Rep . P/54/12.  
Southdown House,  
St. John's Street,  
Chichester, PO19 1XQ  
1/6.

20<sup>th</sup> July 2012.

**Re: 9 Viscount Drive, Pagham PO21 4PE**  
**Planning Application No. P/54/12**

PROPOSED REAR ELEVATION

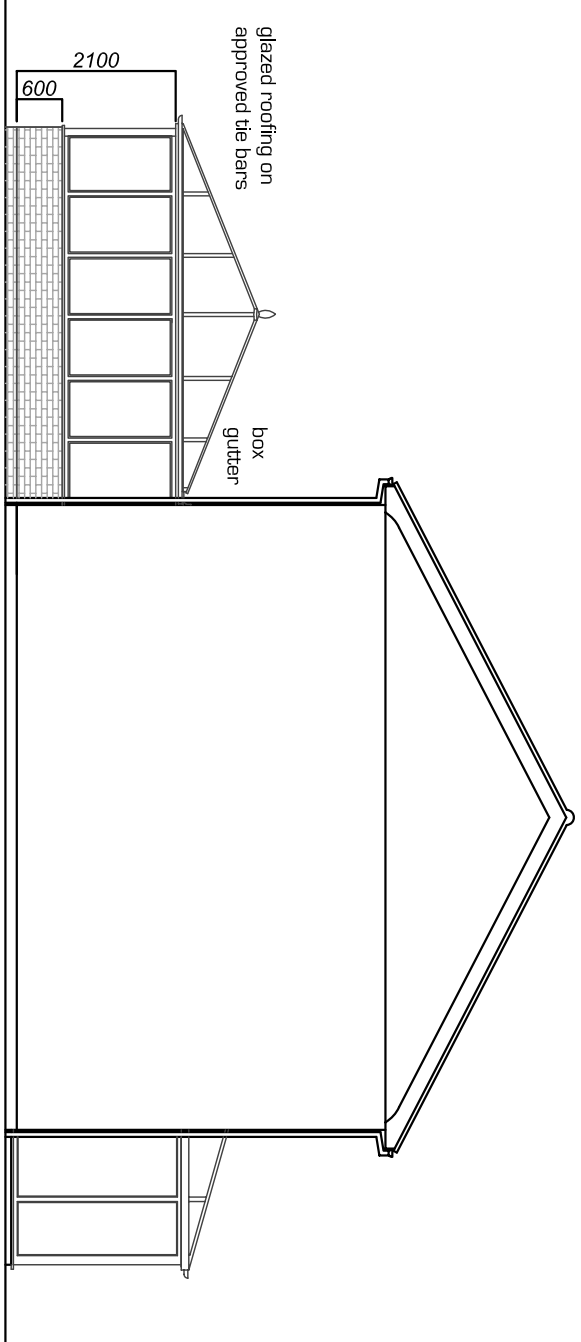
Works are also intended to the rear elevation with patio doors and a change of the cladding. Again our only concern would be about any overlooking of our clients' property but note that it is intended to fit Juliette balconies, and from a practical point of view it would be impossible to step out on to the box gutter and glazed roof of the conservatory.

This is our only concern on behalf of our client who would not want to see any balcony here in any form which would cause overlooking of our clients' garden.
